# CITY OF ALBUQUERQUE

**Re: Innovate ABQ  
Erosion and Sediment Control Plan  
Engineer's Stamp Date 10-7-16 (K14E108)**

Based upon the information provided in your submittal received 10-14-16 the above referenced plan is approved to be included in the SWPPP and to apply for an ESC Permit for Building Permit with the following conditions:

GRADING KEYNOTES

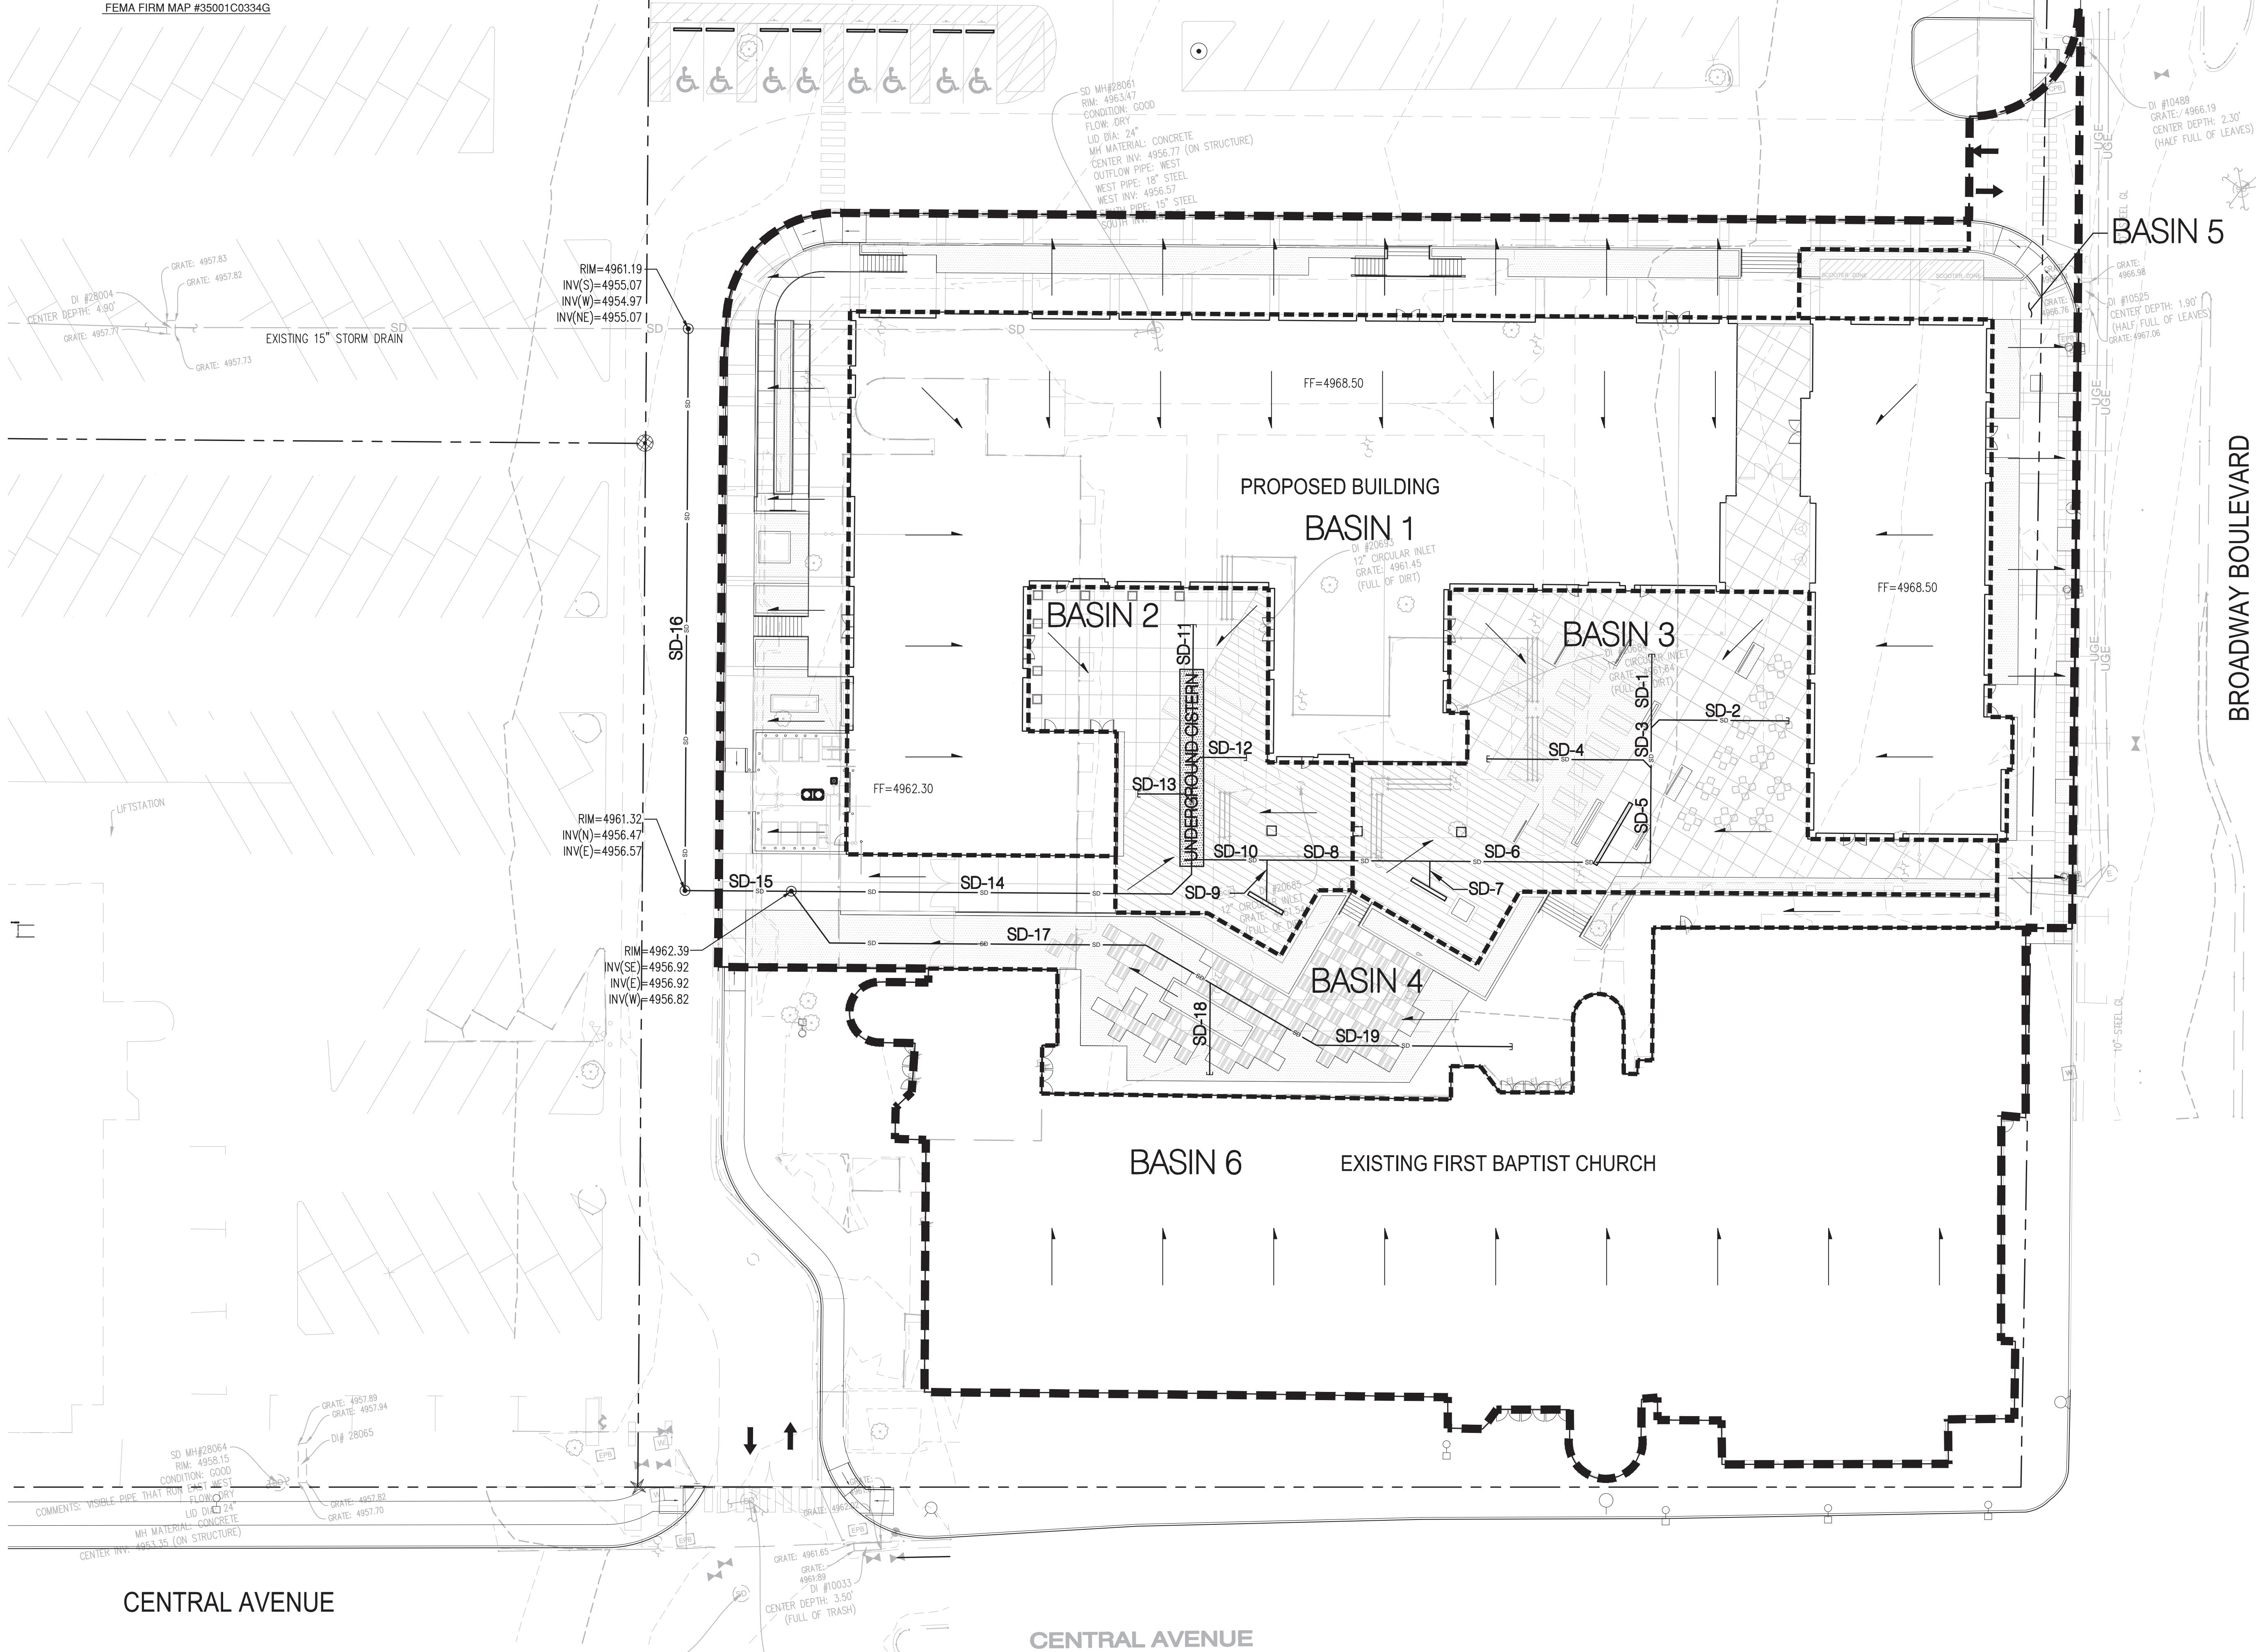
1. Provide inlet protection for area drains specified as Keyed Notes 3 and 4 on the grading and drainage plan.
2. If sediment/debris are present west of the "Limits of Disturbance" shown on the ESC plan: inlet protection is provided for the area inlet in the middle of the parking lot to the west and the mulch sock or similar is provided upstream of the channel in the southwest corner.
